STATE OF NORTH CAROLINA
DEPARTMENT OF TRANSPORTATION

Addendum No. 1

RE: Contract ID: C201588
WBS # 38727.3.GVI
F. A. #IMS-40-3(120)217
Guilford County (I-4715)
I-40/85 from I-85 Bypass to
SR 4121 (High Point Road)

September 18, 2007 Letting

TYPICAL SECTION NO. 6 (RAMPS)

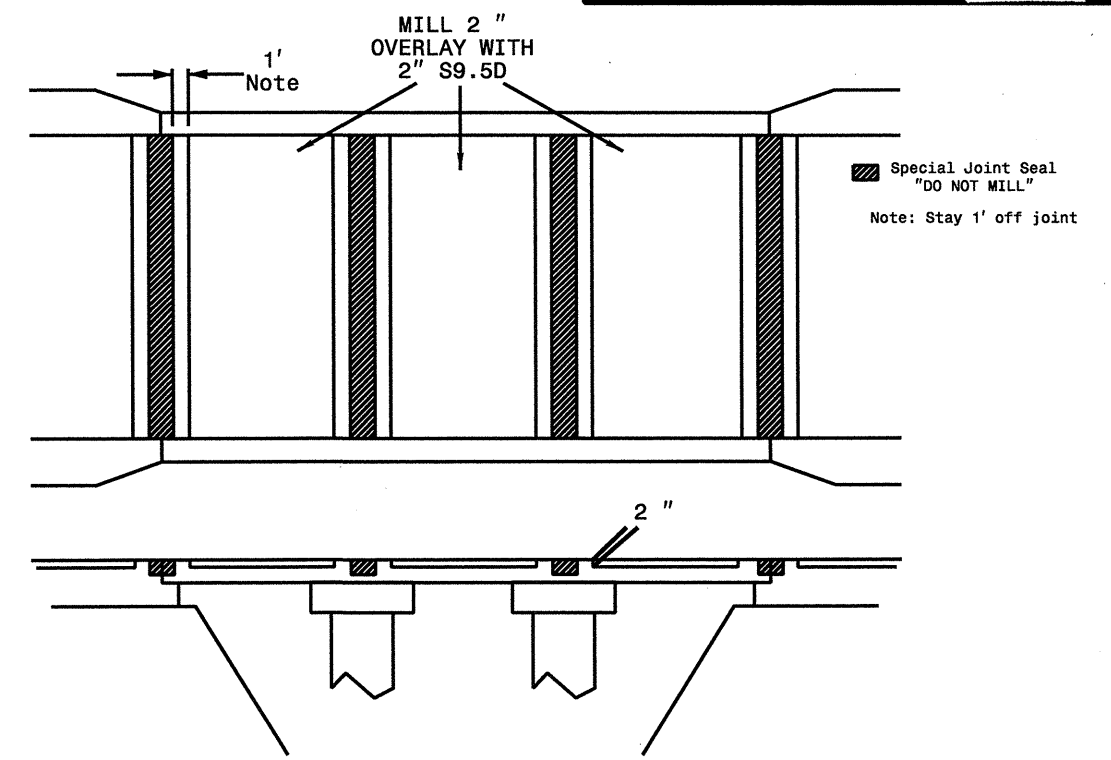
On Sheet No. 3, the milling on Typical 4, 5 and 6 has been revised. Please void Sheet No. 3 in your sketch maps and staple the revised Sheet No. 3 thereto.
